Project Title: Land West of Hook Lane, Pagham, near Bognor Regis
Project Reference: JNY8840-10
Date: 14/05/2019

Application Ref: P/30/19/OUT – WSCC Consultation Response

- 1.1 This Technical Note provides a response to the comments provided by West Sussex County Council (WSCC) dated 10th July 2019 in relation to Application Ref: P/30/19/OUT.
- 1.2 The comments provided by WSCC is included below written in *blue italics* and RPS response is provided in black text.

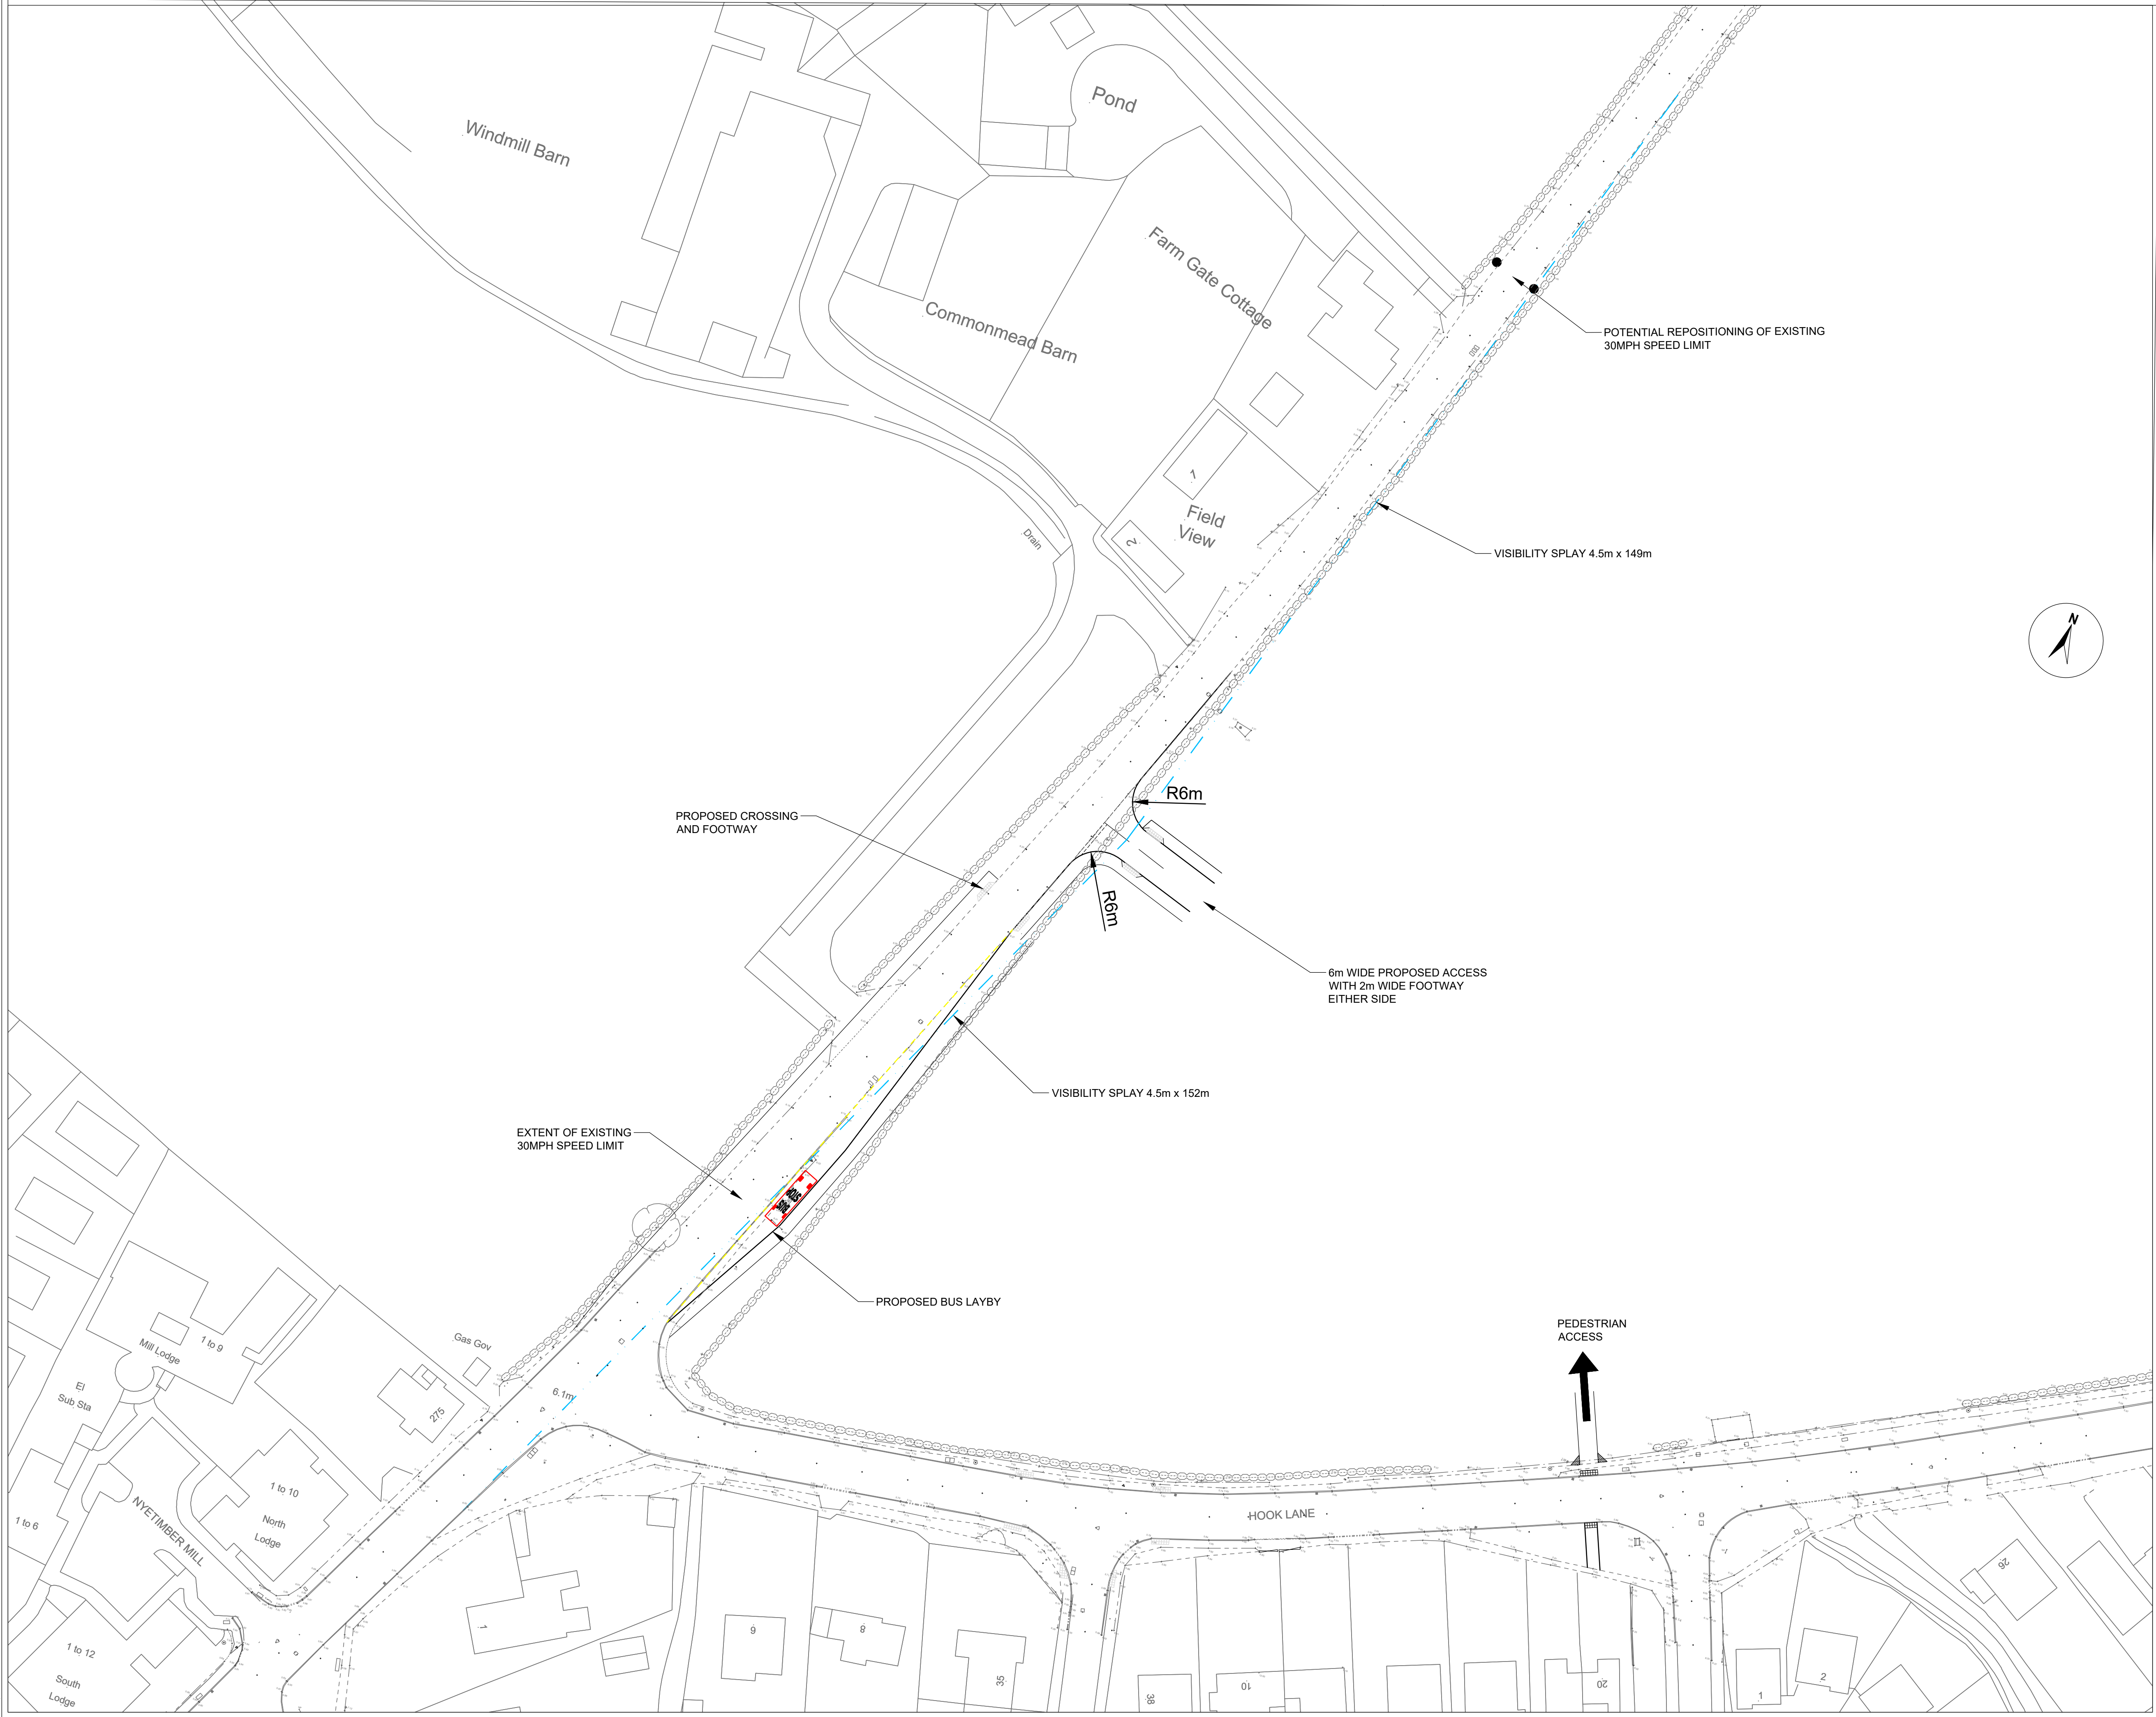
With respects to access, it has been confirmed that the development will have two points of access (one from Pagham Road and a second from Hook Lane) rather than three as suggested within the initial application. Confirmation has also been provided by the safety auditor that the safety audit meets current standards. It was previously confirmed that the design of the access complied with the appropriate design guidance. Again it would be confirmed that the vehicle accesses remain acceptable.

- 1.3 Noted.
- Trip generation for the residential uses has been agreed. Trip generation for the 4,000sqm D1 uses was questioned. The applicant has provided details of the trip generation for the care home (C2 use). Trip generation for this use wasn't raised as these were included in the initial Transport. No further information is included in terms of the D1 uses with is presumed that these still form part of the planning application. As referenced in the initial WSCC comments, consideration would need to be given of the impact of the trips arising from the D1 uses on the site access junctions and those others in the immediate vicinity. It would be unnecessary to consider a wider extent in light of the proposed D1 uses being intended to meet local needs.*
